SCOPING OPINION:

Proposed Teddington Direct River Abstraction

Case Reference: WA010006

20 November 2024

Title:  
 PLAN 2.1 – ENVIRONMENTAL CONSTRAINTS PLAN SHEET 1 OF 4

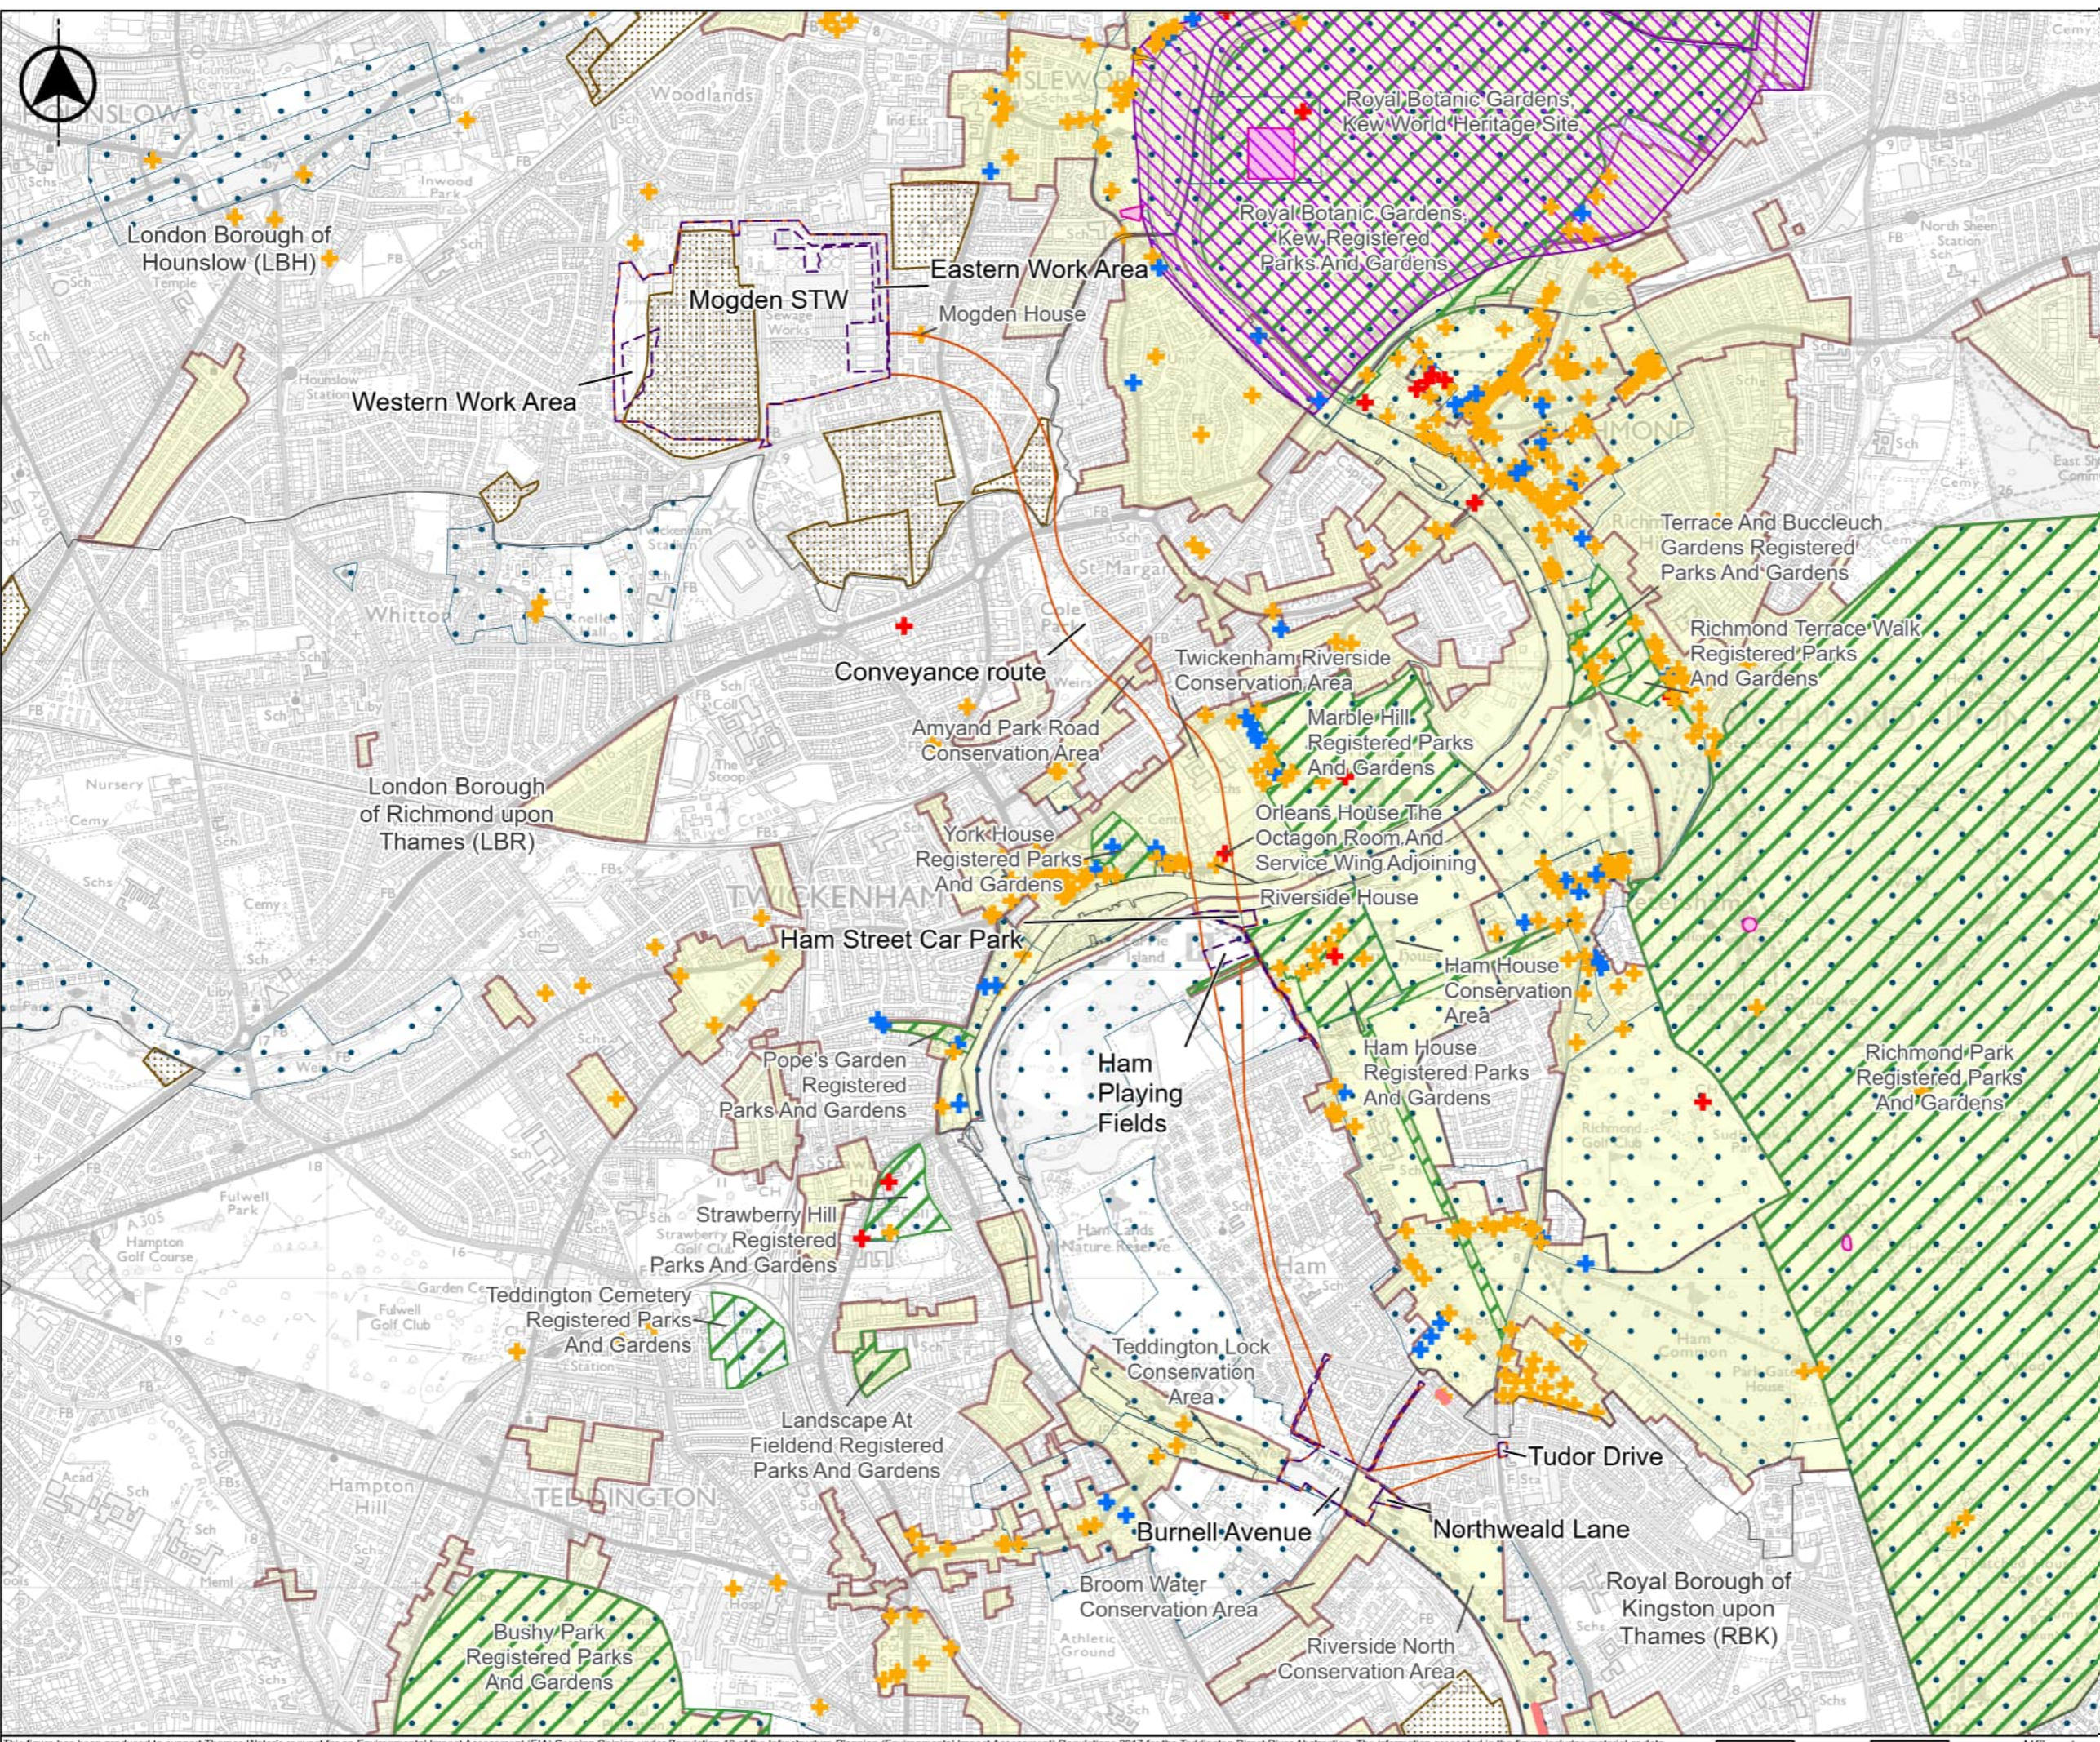
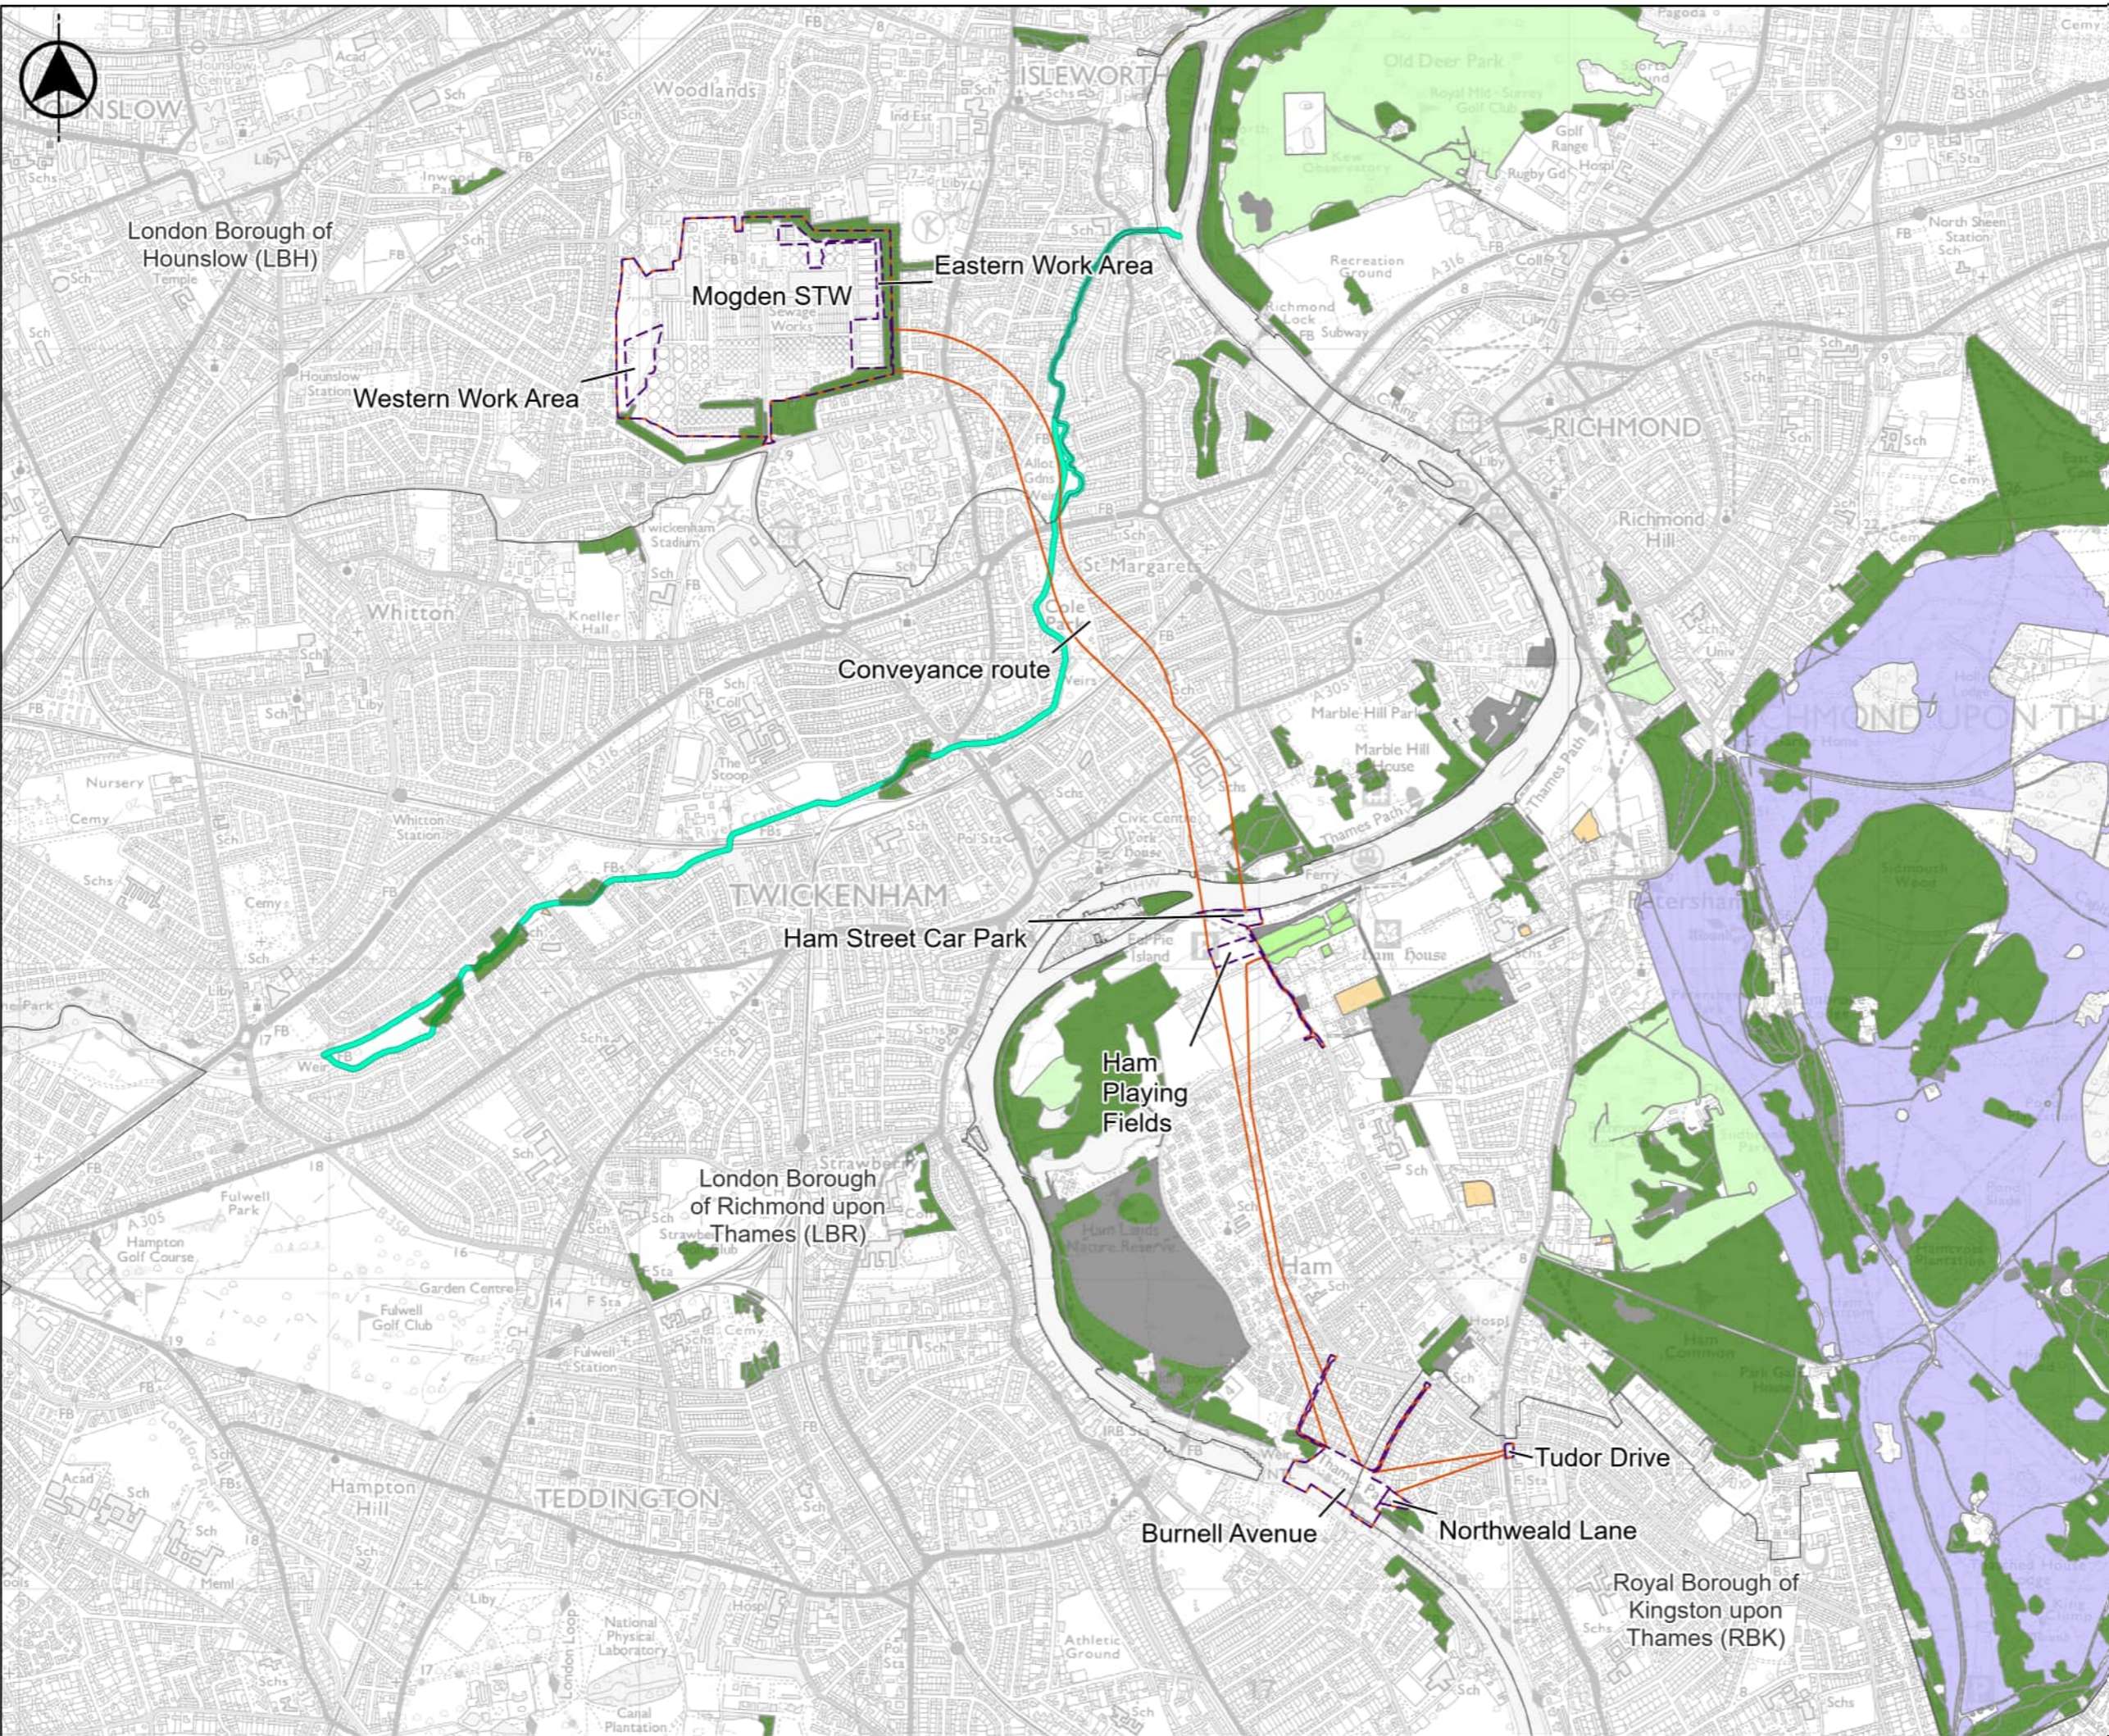
33.17	Plans 2.1 and 8.1 (Appendix A)	Figures	Figures in the ES should include labelling of heritage assets to aid understanding.
33.18	n/a	Non-designated above ground heritage assets	The ES should confirm if there are any non-designated or locally listed buildings within the study area and indicate their location on a plan. Where significant effects are likely to any assets identified, these should be assessed in the ES. The Applicant's attention is drawn to the comments of Historic England and London Borough of Richmond upon Thames (Appendix 2 of this Opinion).
